## KITTITAS VALLEY FIRE & RESCUE

October 13, 2008

I have reviewed the Application for the Wildcat (LP-08-24) and Tiger (LP-08-22) Plats. I provide review of proposed development and construction for Kittitas County Fire District 2. The Fire District has no code enforcement authority so my input is, for the most part, informational only.

WILDCAT PLAT

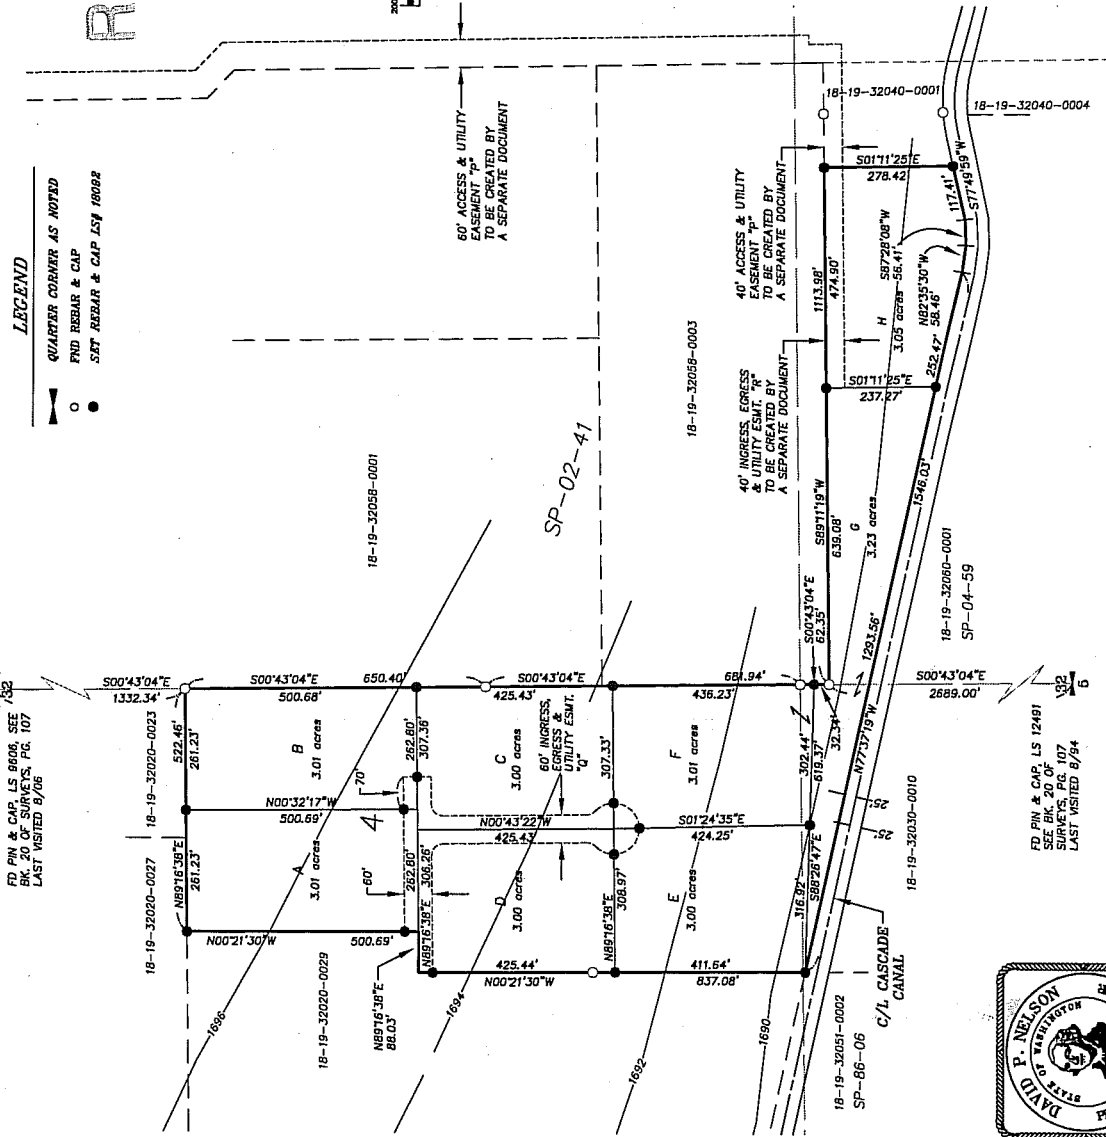
1. The addresses need to be clearly visible from both directions at the county road for all properties.
2. The fire department access road needs to be capable of supporting 75,000lbs in all weather, be 20' wide, provide 13'6" vertical clearance and provide for adequate turn-around for fire department apparatus in accordance with IFC 2006 – Appendix D. All cul-de-sacs need to be compliant.

4. Depending on the eventual scope of this project, a second ingress/egress road may be required by the IFC.
